Tel: 01895 250230
Case Officer: Nicola Taplin
Email: ntaplin@hillingsdon.gov.uk
Date: 19th March 2020
Our Ref: 25767/PRC/2020/16

RE: Demolition of existing house and erection of a four storey building, with basement, to provide 7 x 2 bed and 2 x 3 bed self-contained flats

SITE: 72 Harefield Road Uxbridge

Second floor
First floor
Ground floor
Lower ground floor

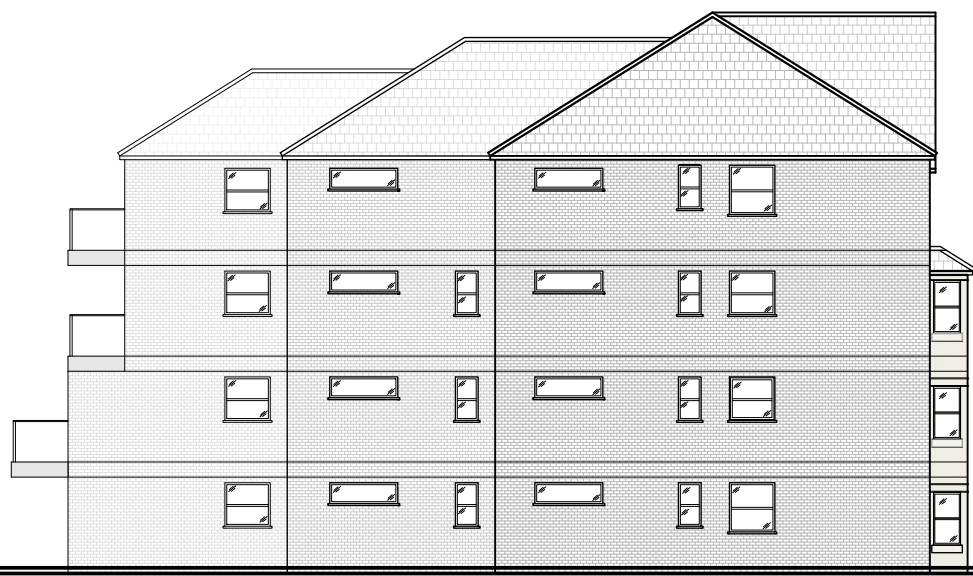
The submitted floor plans indicate the principle windows would face the front and the rear of the site. The side windows appear to serve non habitable rooms and should be obscure glazed and non opening below 1.8m. There are proposed rear facing balconies and these would also need to be screened by 1.8m high privacy screens along the sides. It is therefore considered there would be no significant loss of privacy to the adjacent properties.

PROPOSED SIDE ELEVATION
SCALE - 1:200

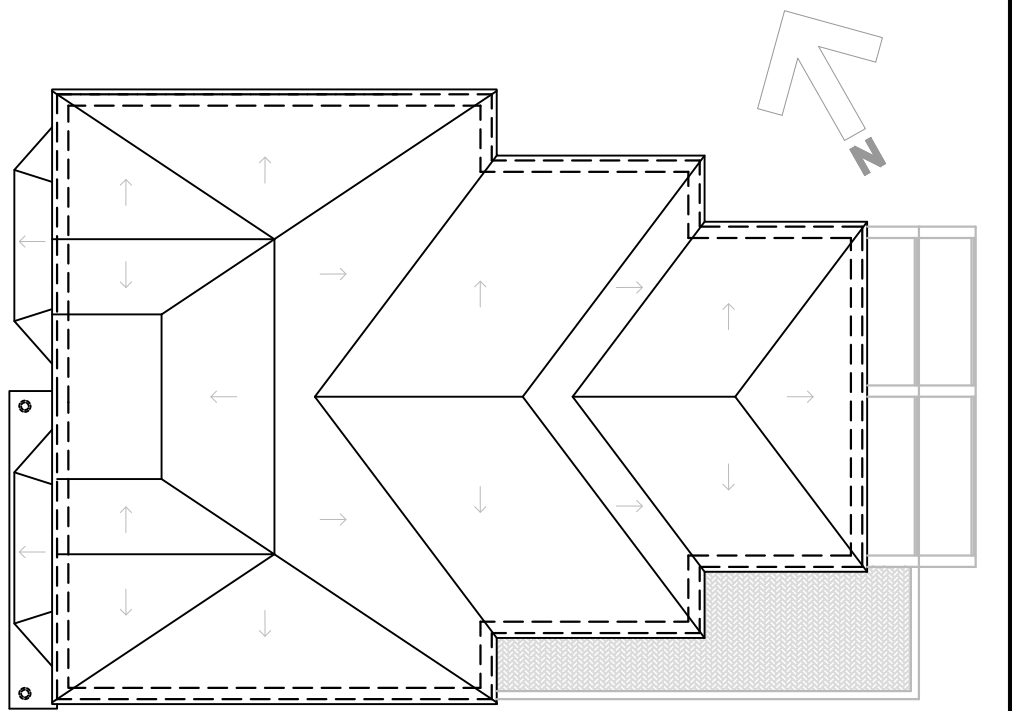
Concerns are raised in terms of the conflicting roof forms, especially the rear roofs which would be at odds with the frontage roof form, resulting in an incongruous addition to the street scene.

At the meeting the applicant discussed the roof form of the rearwards projection. The argument advanced was that the rear elevation would not be particularly visible. It is however considered that views of the roof of the proposed building would be visible from public viewpoints and it would be necessary to consider a roof form that better respects that of the frontage element. This may involve a reduction in the scale and width of the building to allow for a steeper roof pitch which would be more sympathetic. The applicant also advised that a crown roof may be explored.

Although the proposal would not appear to contravene a 45 degree line of sight from the rear windows, the increased bulk of the proposal extending so significantly beyond the rear of the neighbouring building at an increased height would result in a significant sense of enclosure and overdominance. The adjacent flats to the south are sited 2.2m off the boundary with the application site. The proposed building would project over 11m to the rear of these flats (including balconies) which would be considered to have an unacceptably dominating impact. Number 74 Harefield Road has 4 windows in its flank elevation of the outrigger to the rear, two at ground floor level and two at first floor level. These windows appear to be clear glazed and would be sited 8m away from the rearward projecting part of the proposed building which would result in an unacceptably dominating form of development. At the meeting the applicant advised that he would explore the issue of outlook and light. It was suggested that a 15m separation distance would be appropriate to windows serving habitable rooms in number 74.
